Sign permit - 170 Anderson St.

I am looking at your permit application to add two new signs to Cycle Maine. I had a few questions for you.

SHEET TITLE:  
SITE PLAN  
LAYOUT

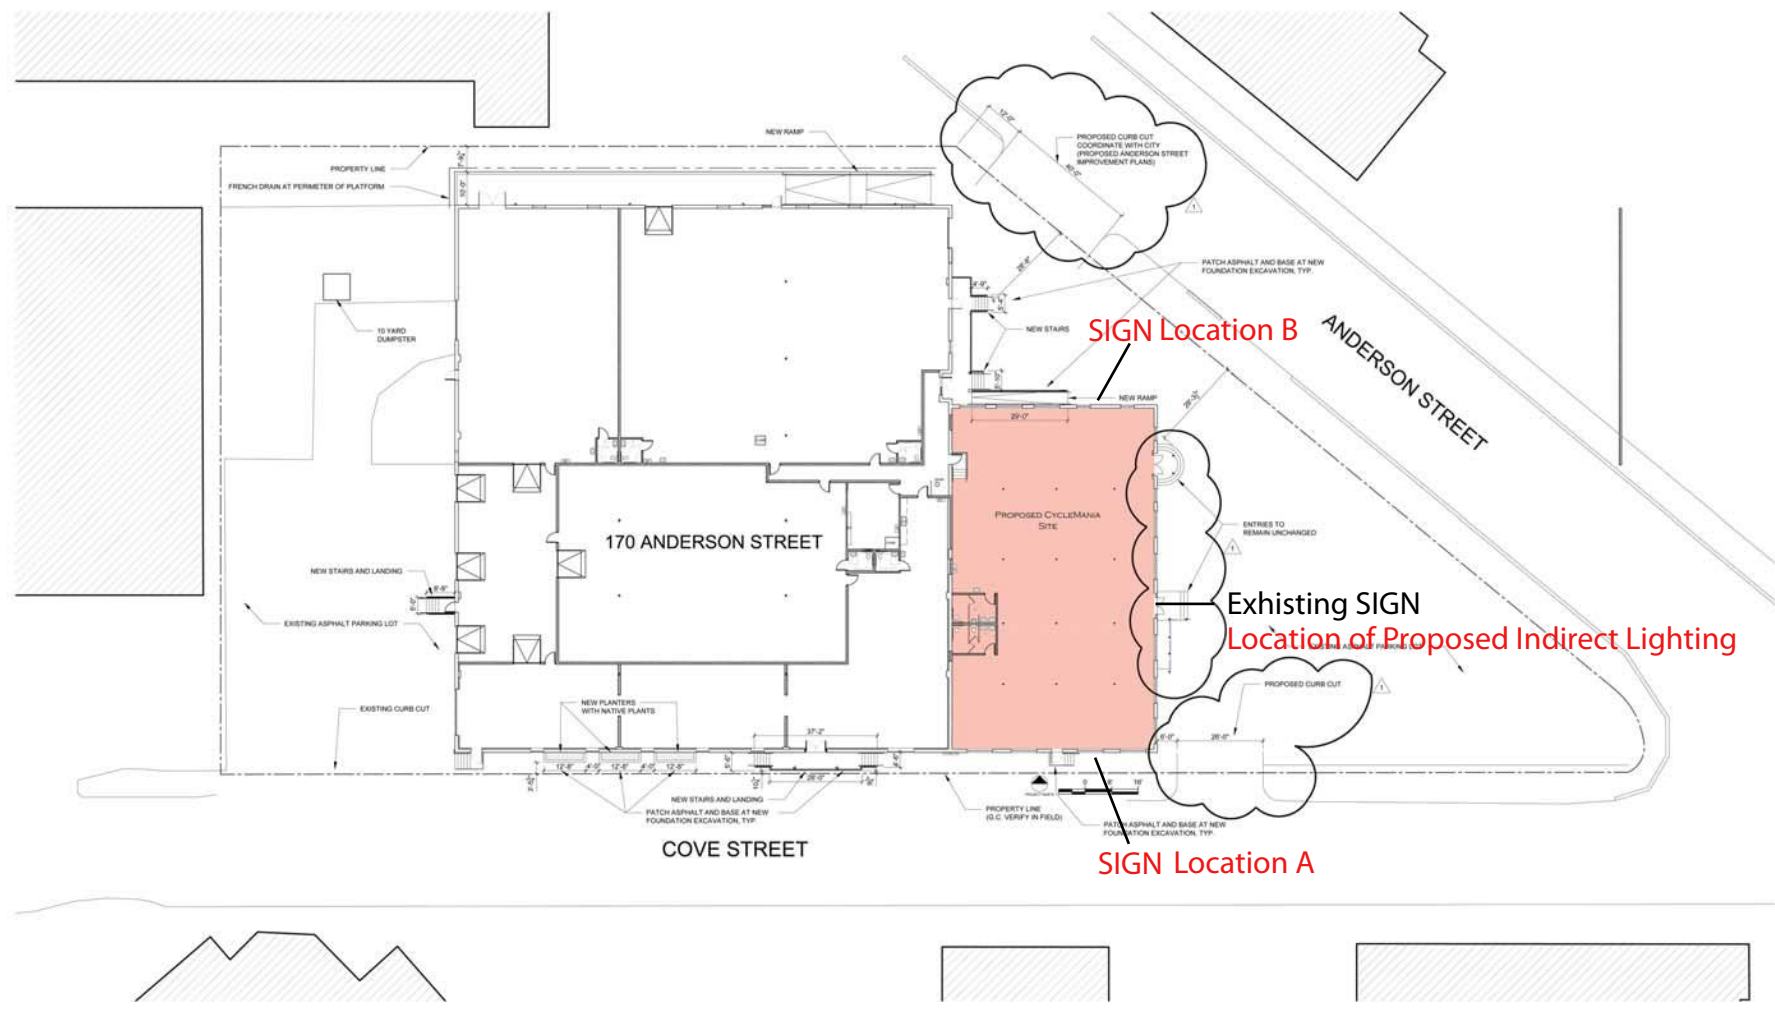
First, this zone typically allows one sign for each tenant, plus one additional sign on each building facade. In looking at the Google Street view, it looks like the only other sign on the building is a small one on the entryway for Zootility. Can you confirm if this correct? If we approve the two extra Cycle Maine signs it will "use up" the ability of any other tenant to have more than their one allotted sign on the same facades.

Second, can you provide some rough measurements (length by height) of the two facades that the new signs will be placed on, so that I can verify that the signs will meet the maximum size allowance of 2% of the facade area?

To clarify, the rules allow each tenant to have one sign. The rules also allow one additional sign on each facade of the building. Once someone uses the "extra" sign provision on any particular facade, no other tenant would be allowed any "extra" signs on that facade outside of their one tenant sign. Although I realize that Zootility is on a different facade, the opposite side facing Cove Street appears to be a shared facade between your business and whoever occupies #71 Cove Street. Are there any other signs on that side?

OK, we will get you your permit shortly. I think it's still arguable whether Angela Adams would be considered a separate facade, considering it is one long, unbroken wall on that side. But since they have not come in to have even one sign, never mind two, I think we can cross that bridge if/when it happens.

-We will be adding the signs the exterior of the building the we lease, not Zootility. They do lease next door, but it is a different façade.

-The H & L of the side of the building is 14' x 63' (882 sq ft). The sign proposed is 1'x12' (12 sq ft). This should meet the size requirements, if not, we can reduce the size of the signs.

I would like to continue with sign application for CycleMania at 65 Cove St. as we discuss via phone a few weeks back. Attached is the approval from the Landlord. The other matter we discussed was the additional signage that is allowed on Cove St side of the building. The building is 2 buildings CycleMania façade being 14'h x 63'l and the Angela Adams façade being at 25'h x 150'l should give plenty space for 1 or 2 signs for Angela Adams with a new permit when they decide to do so.
